An
Bord
Pleanála

Inspector's Report

ABP-314487-22

Dredging of harbour, treatment of dredged material, reclamation of land, landscape reclaimed land, construction of slipway and construction of embankment and rock armour around reclaimed land

Figure 2. Red line boundary of proposed construction works including site layout (excerpt from planning drawing no. 19934 -5002 Site Layout Plan).

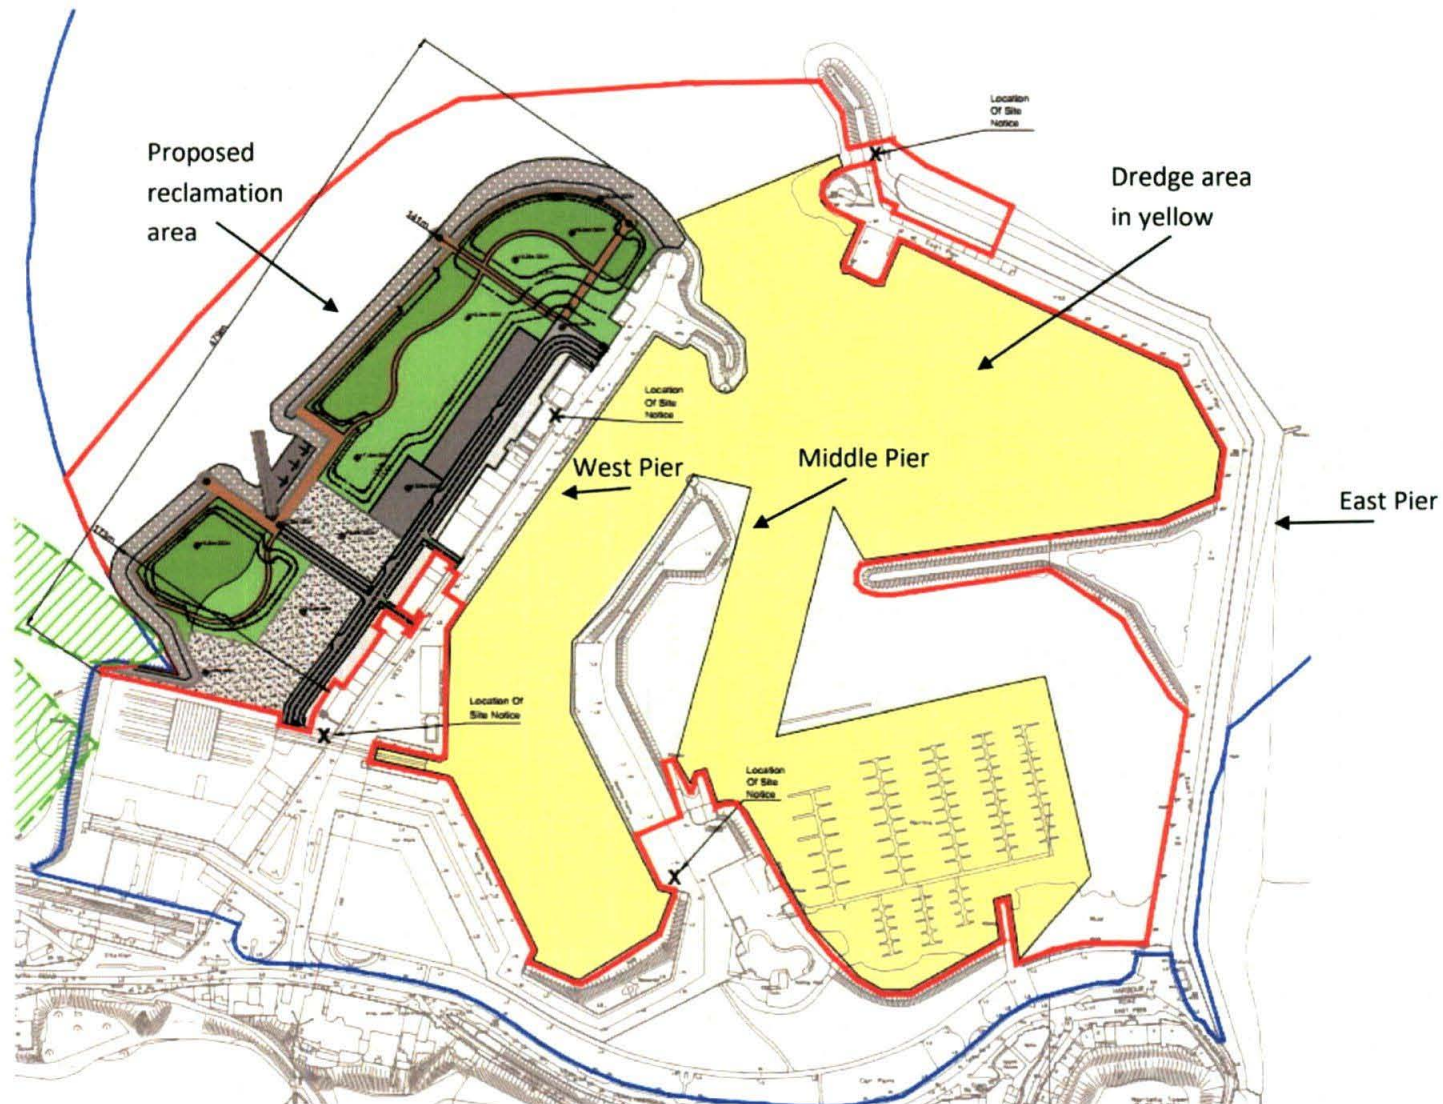
1. The northern end of the West Pier still retains historic features such as the West Pier Roundel. The reclaimed area should be reduced to ensure that the West Pier Roundel is maintained as a tip of a pier jutting out into the sea.
2. The extent and layout of the landbank should be re-examined to enable as much of the original plan of the historic pier to remain legible as possible and any surviving historic features on the western face of the pier are avoided.

3. Reconsideration of the position of the proposed road, to allow for a more acceptable boundary interface between the rear of properties fronting onto West Pier.

4. Clarify why the proposed reclaimed land rises to the north.
5. An Instrument Flight procedure (IFP) opinion is required.
6. Having reviewed the submitted EIAR together with the details of the proposed development and associated documentation the applicant is requested to supply the following information and submit a revised and updated EIAR addressing all of the items raised.
